CITY OF ALBUQUERQUE

Re: Gibson Apartments 4801 Gibson Blvd SE
Request for Permanent C.O. – 30 day Temp.
Engineers Stamp Date: 10-31-11 (L17-D024)
Certification Dated: 12-02-13

Based upon the information provided in the Certification received 12-02-13, the above referenced certification is acceptable for a temporary Certificate of Occupancy of 30 days. A Permanent Certificate of occupancy will be given once the following issue is corrected.

GRADING PLAN

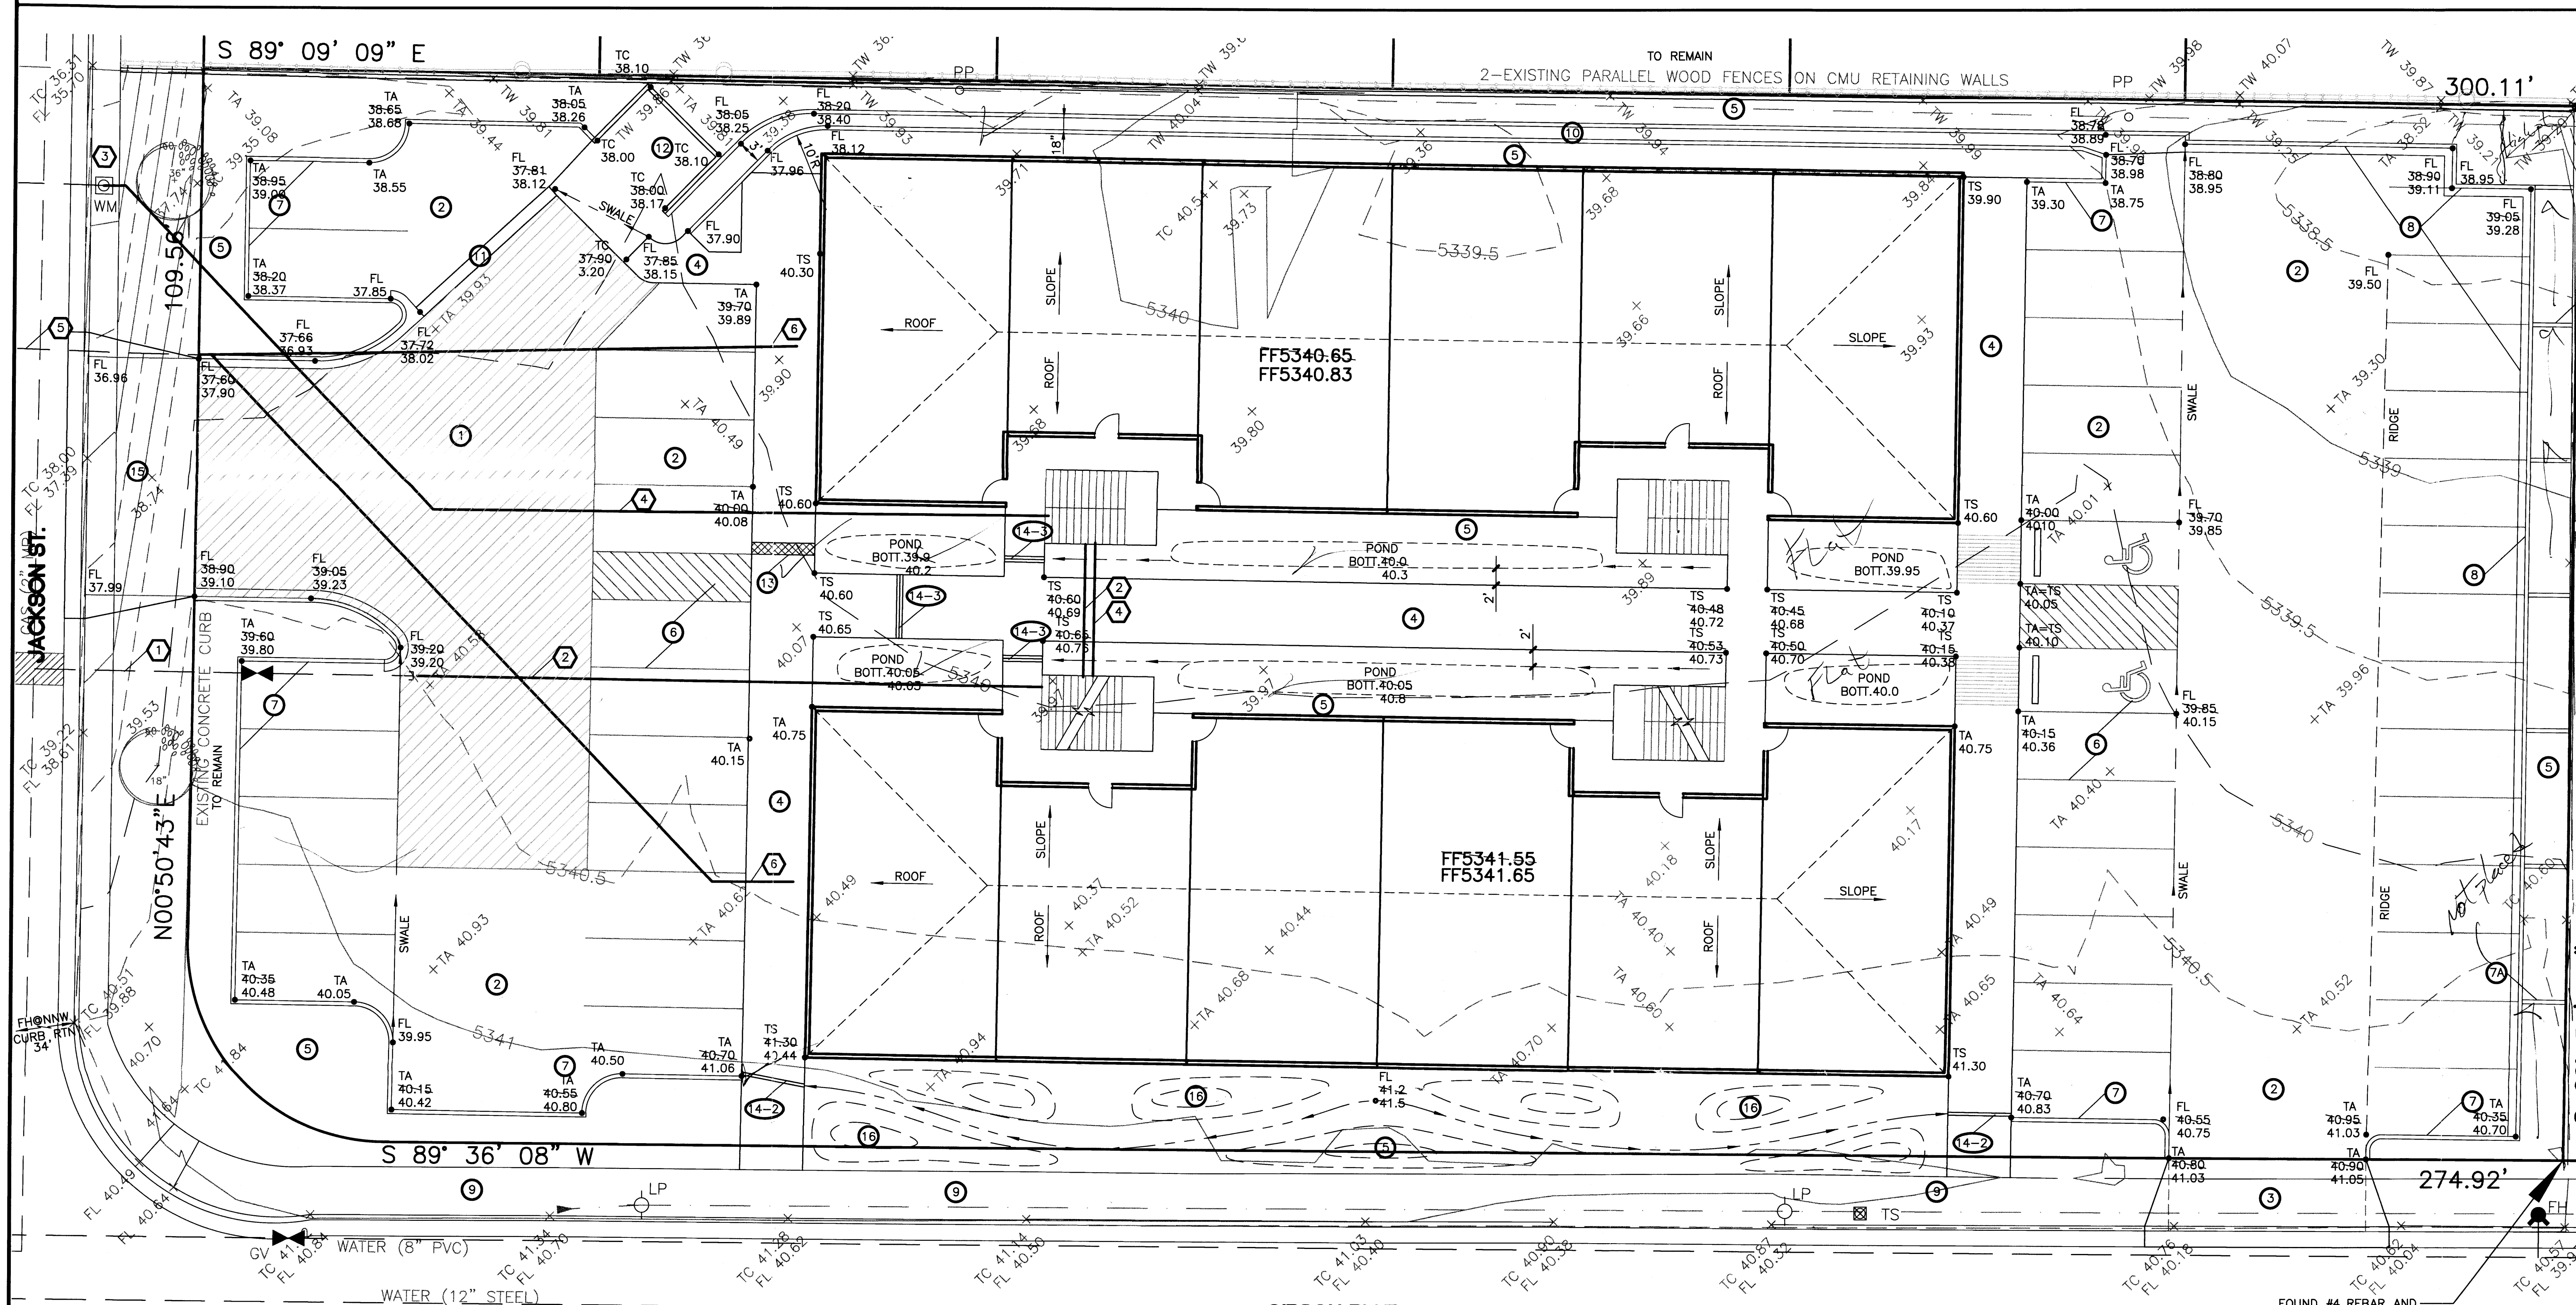
- The NE corner of the landscape area is missing a corner block. This will allow moisture to escape into the lots just to the NE and east.
